**CITY OF ALBUQUERQUE  
PLANNING DEPARTMENT  
July 18, 2012  
DRB Comments**

**ITEM # 10**

**PROJECT # 1009328**

**RE: Lot 35, Crestview Patio Homes**

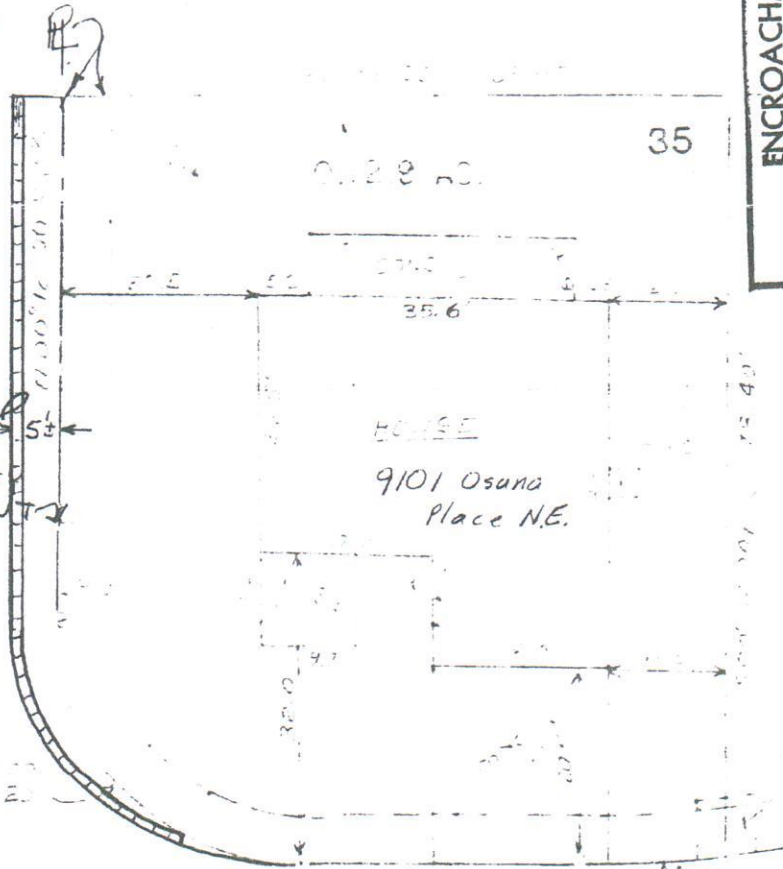
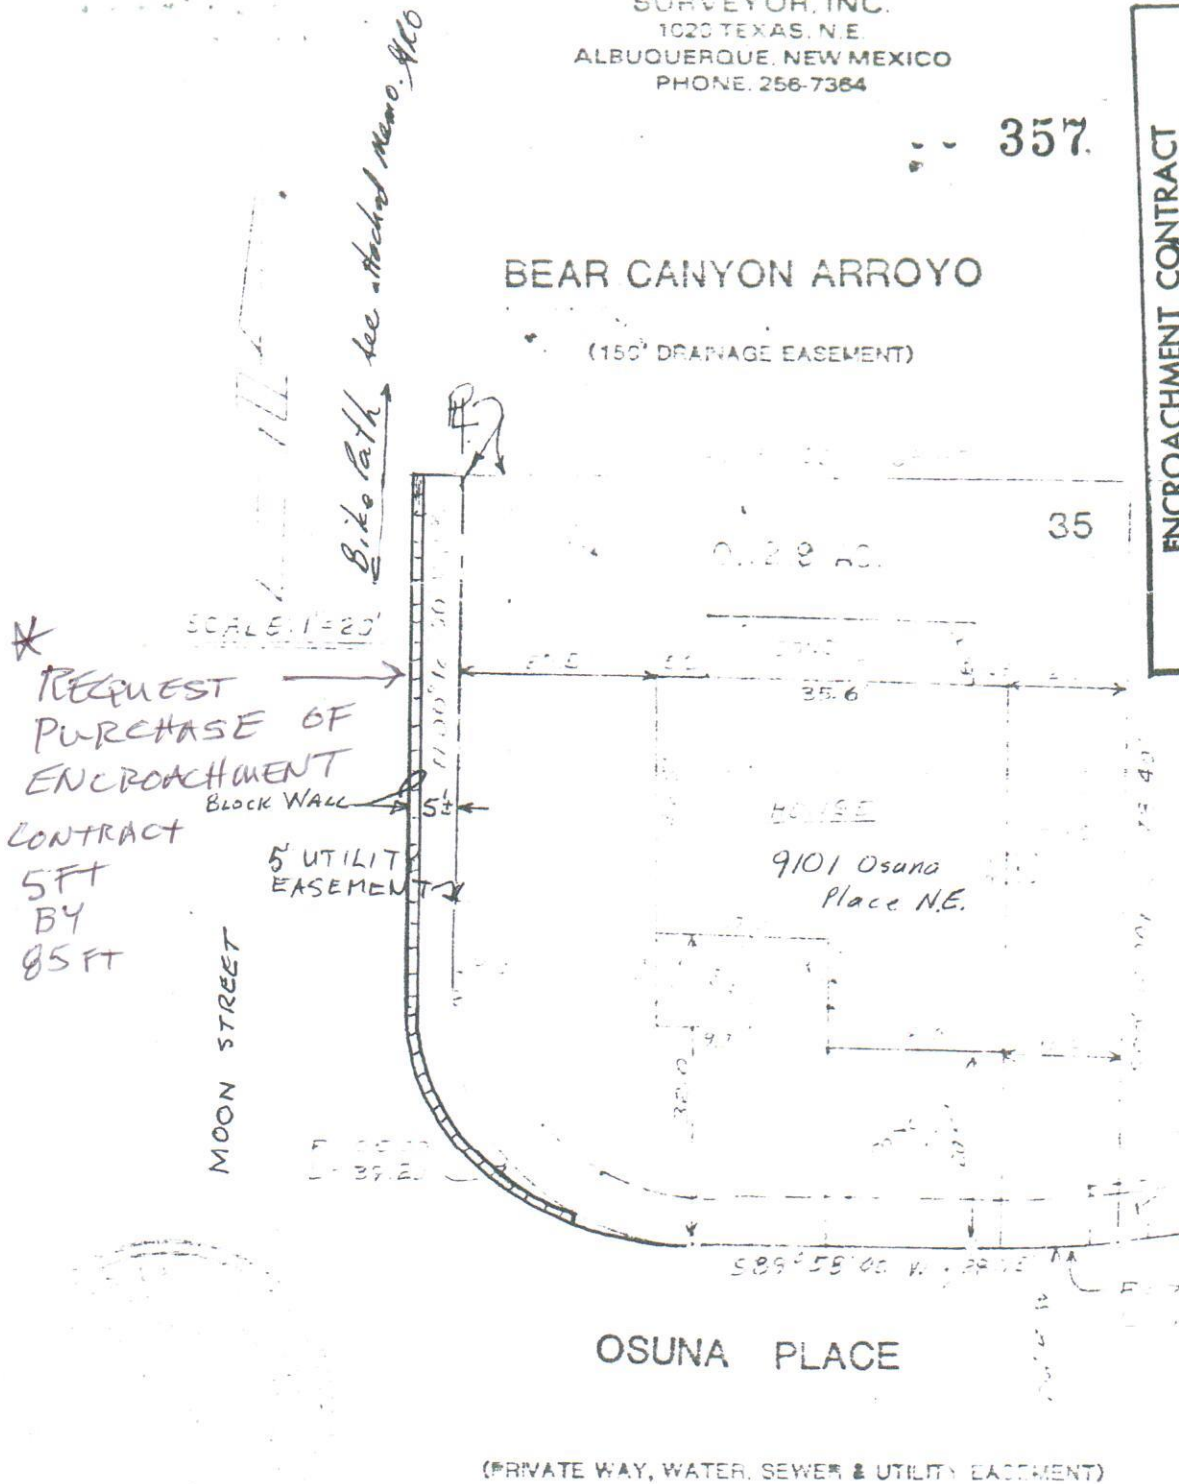
Refer to comments from Transportation Development regarding the potential for vacation of right of way for Moon Street. If vacation is feasible it would require a vacation application, with an advertised public hearing by the DRB and a fee of \$300. If there is no objection and if the vacation is approved, in order to complete the vacation the vacated right of way would have to be purchased from the Real Property Division and it would have to be replatted into the adjacent lot within one year by a surveyor licensed in New Mexico; the fee for a one lot subdivision would be \$235.
